Harnett County Environmental Health

EXISTING SYSTEM APPROVAL

Proposed Property Improvement: Adding a 12'x24' shed

Operation Permit/ATO #: SFD2211-0032

PERMIT # SFD2211-0032

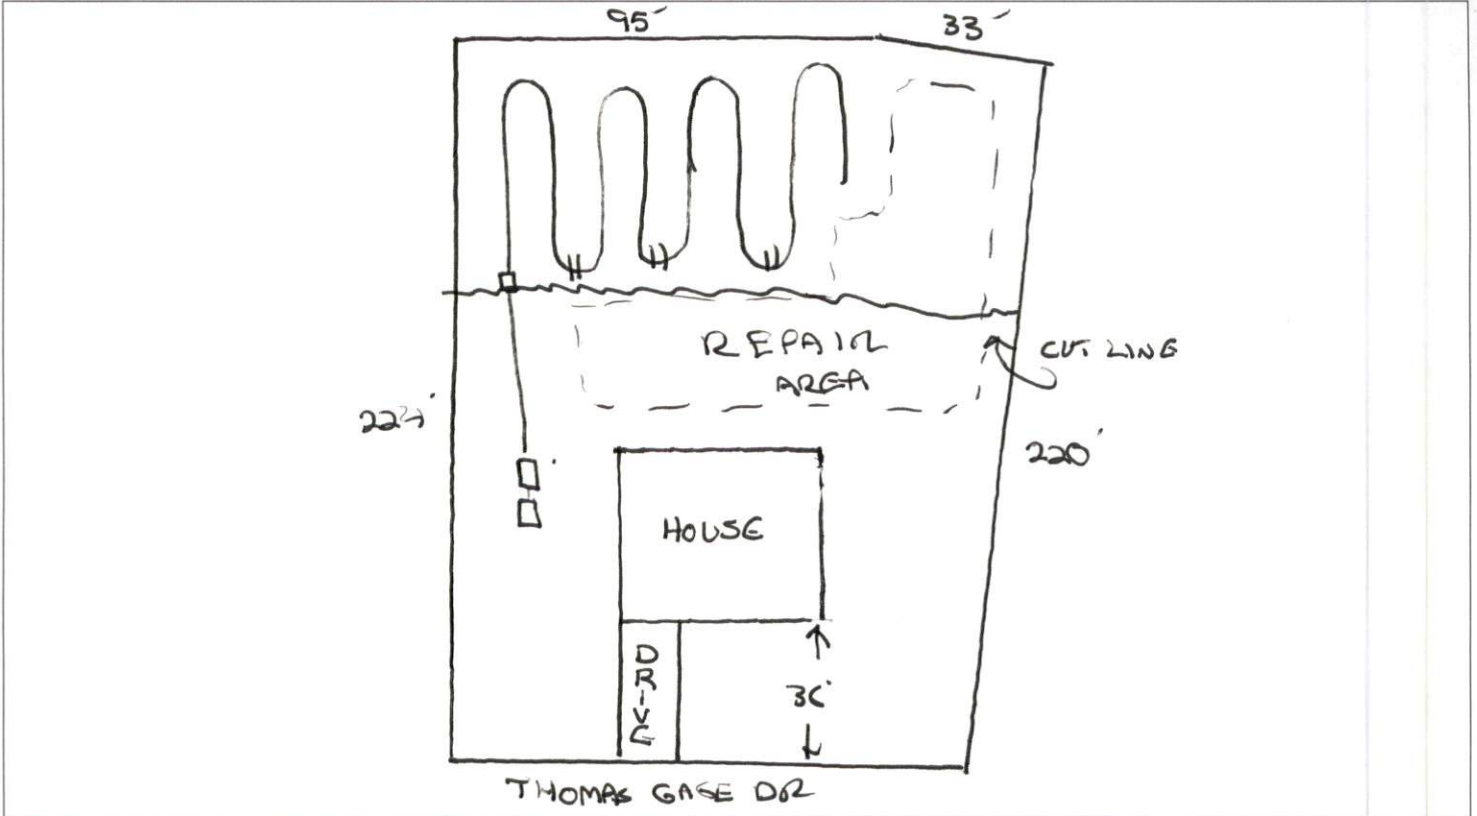
Approval Conditions: Septic permit designed for 4 bedrooms but 3 bedroom house built. Smaller repair area needed then is shown on OP
